Engineers Comments Regarding Surface Water Drainage

Application Reference:	WA/44/25/PL	Reviewer Reference:	ADC/PC
Planning Officer:	Harry Chalk	Date of Review:	10/09/2025
Site Name:	Longacres Eastergate Lane Walberton BN18 0BA		
Application Description:	Erection of 1 No self build dwelling with associated parking and landscaping (resubmission following WA/101/24/PL). This application is a Departure from the Development Plan and is in CIL Zone 3 and is CIL Liable as a new dwelling.		
Assessment Number:	1 of 1

PROPOSED DRAWING 2a
Site Plan
November 2024
1:200 at A3

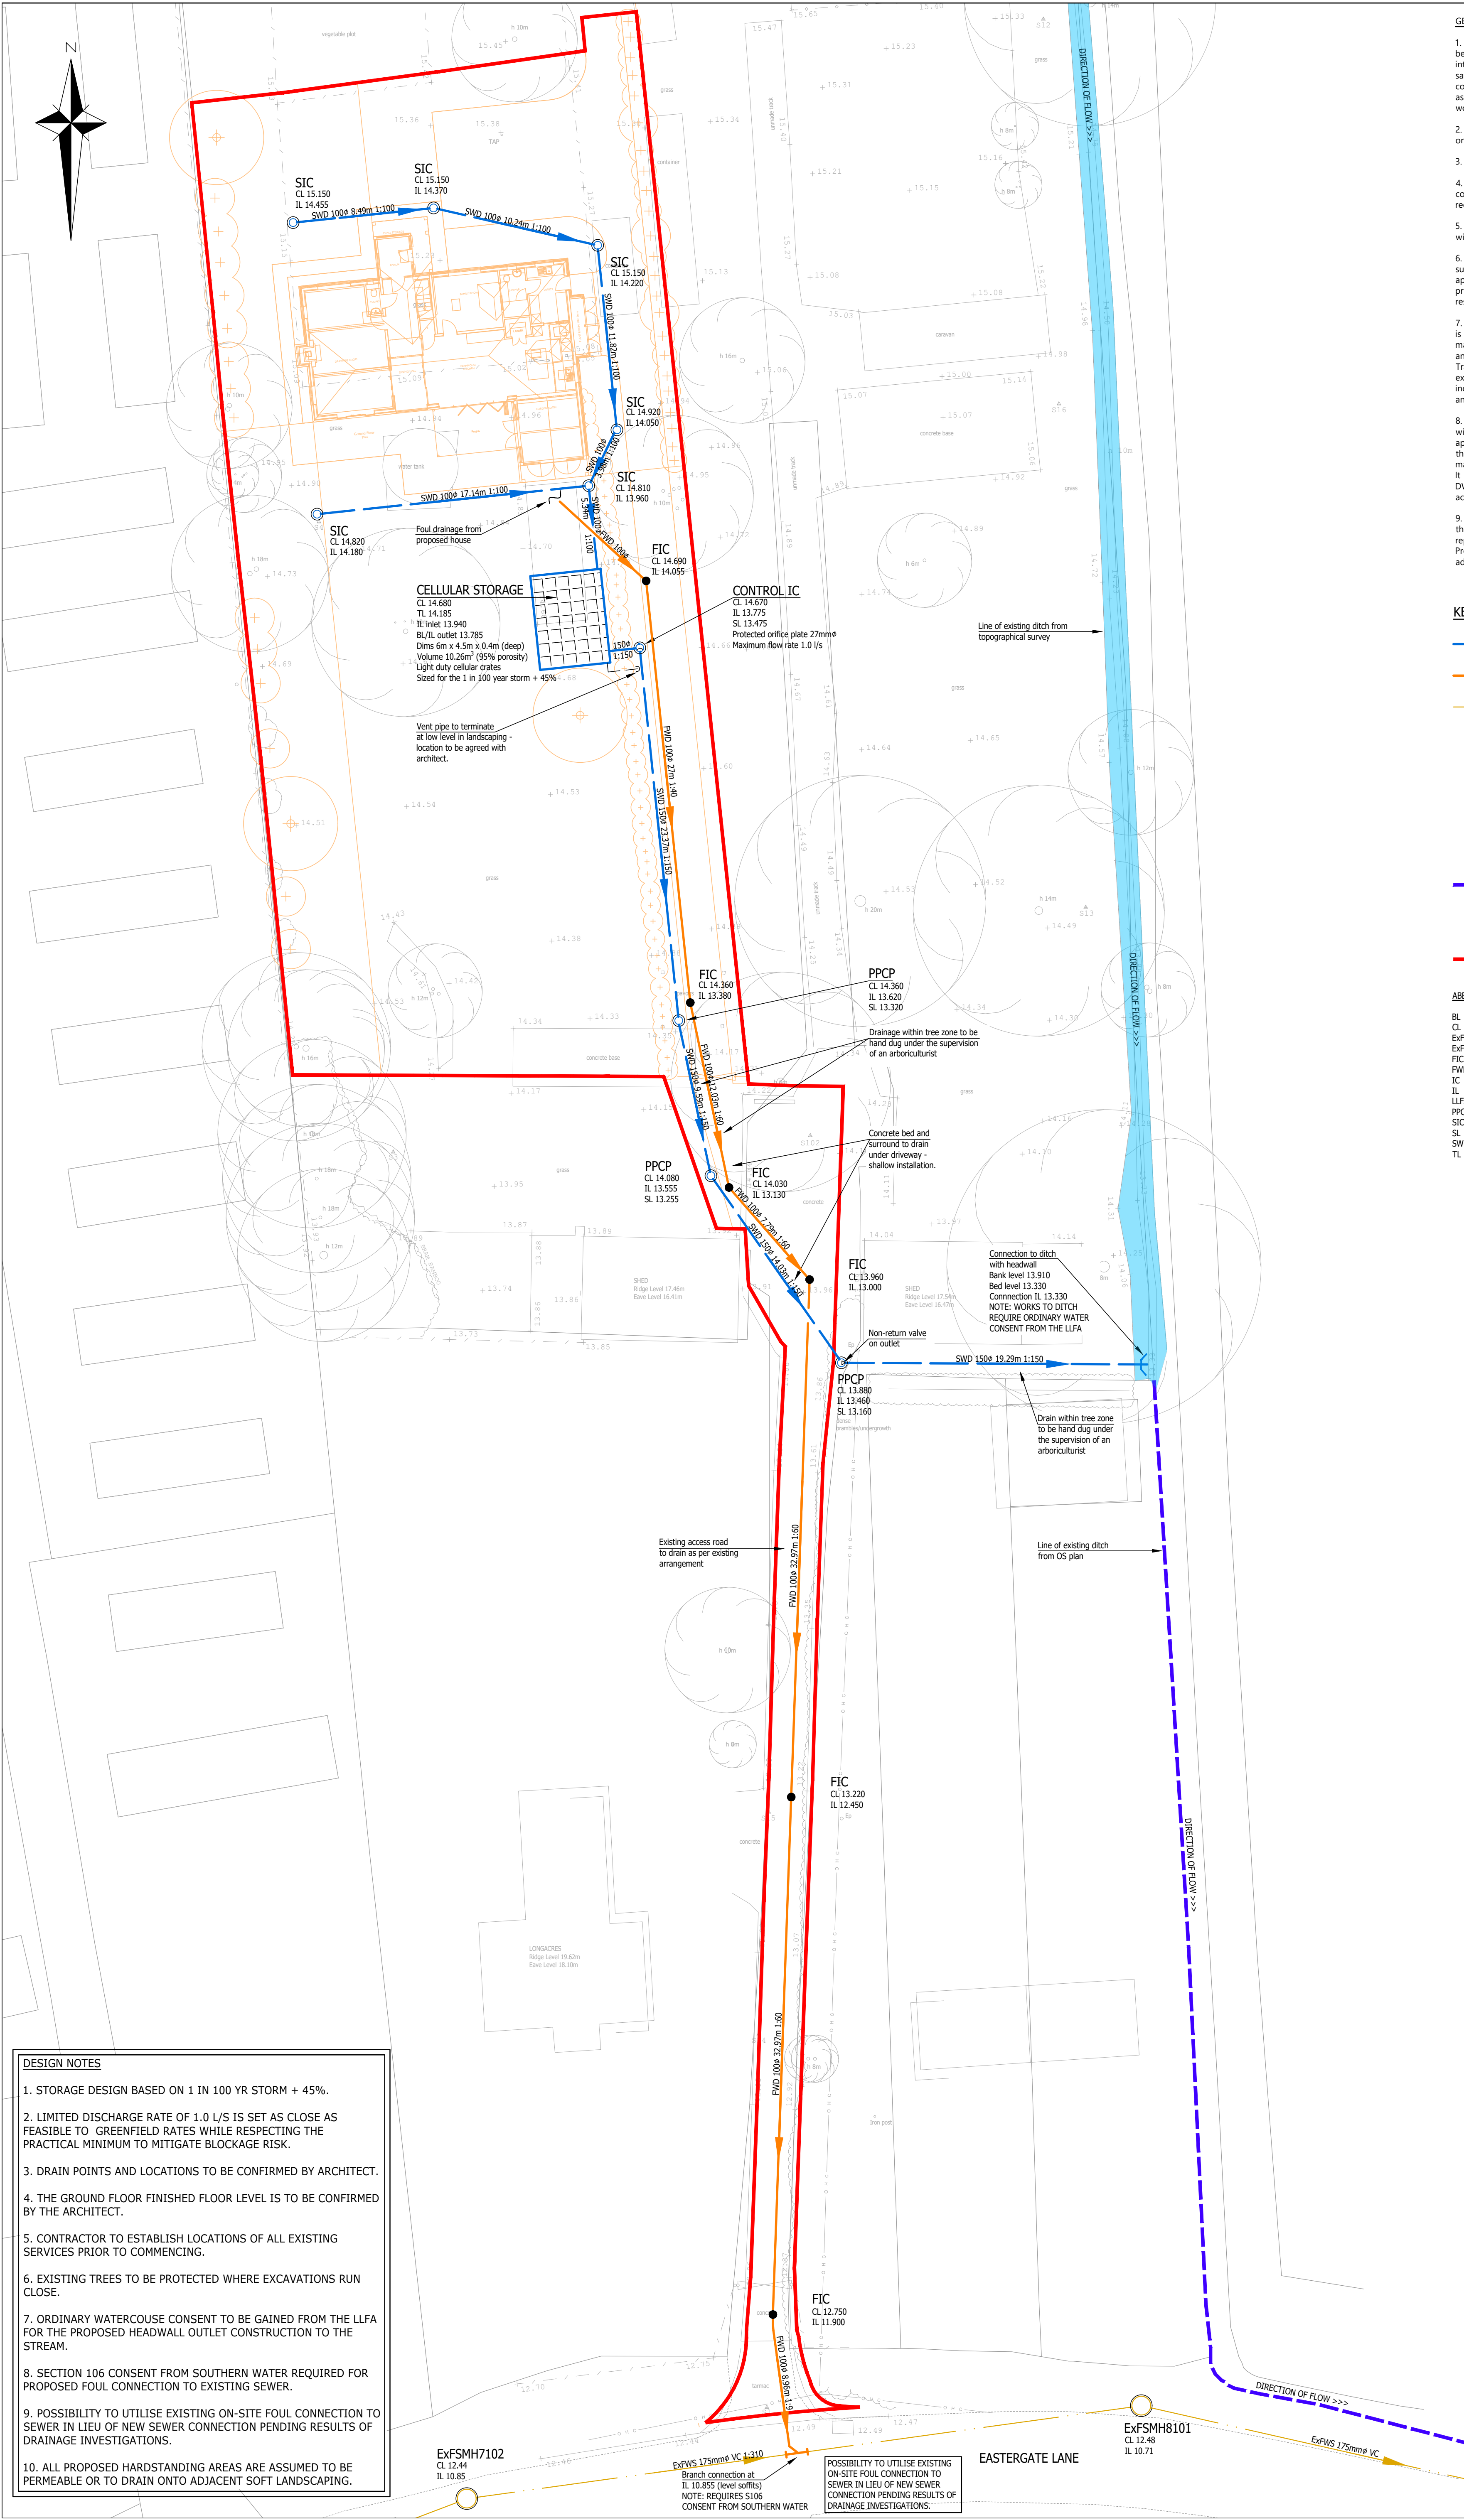
In order to facilitate the connection to the watercourse and achieve freeboard between the bed of the watercourse and the proposed invert of the outfall pipe, the applicant is proposing to undertake significant re-grading of the watercourse (up to 400mm increase in depth). Further information is required to evidence that this is possible without detriment to the existing watercourse/banks/adjacent land.

It will be necessary to provide an existing and proposed longitudinal section through the watercourse with supporting existing/proposed cross sections. If the works impact third party land then appropriate permissions will need to be evidenced.

100mm of freeboard is currently being achieved and needs to be maximised as much as possible, as this helps reduce the risk of the pipe becoming obstructed by debris and silt in the watercourse.

All pipelines are to connect soffit to soffit level. It appears this is not being achieved in all cases ie. pipeline 3.001.

Pipeline 4.000 – 100mm pipe gradient needs to be min. 1/100 gradient and achieve a soffit to soffit connection. Increasing the pipe diameter which would enable a slacker gradient, could help resolve the issue.

There are potential clashes between the proposed surface water drainage and proposed foul water drainage, where they cross ie. pipelines 1.003 and 3.001. The designer will need to evidence that there is no conflict.

A non-return valve is proposed on the pipe outlet from chamber PPCP3 (to reduce the risk of backflow from the watercourse reducing storage in the system). A construction detail will be required to support this proposal, to ensure the arrangement is fit for purpose. This can be dealt with via condition/detailed design.

Formation and finished levels of proposed permeable paving to be indicated on the Drainage Layout Plan, supported by a typical construction detail.

Indicate proposed finished floor/garage slab levels of property on Drainage Layout Plan.

Exceedance flow routes are noted. The applicant may need to consider measures to reduce the risk of excess flows impacting buildings beyond the southern boundary. Bunding may assist in this respect.

Please indicate all root protection zones (RPZ) for existing trees to be retained and proposed trees on the Drainage layout Plan, to ensure no conflict/detriment. All RPZ to take account of trees reaching maturity. Any existing trees to be removed to be clearly indicated.
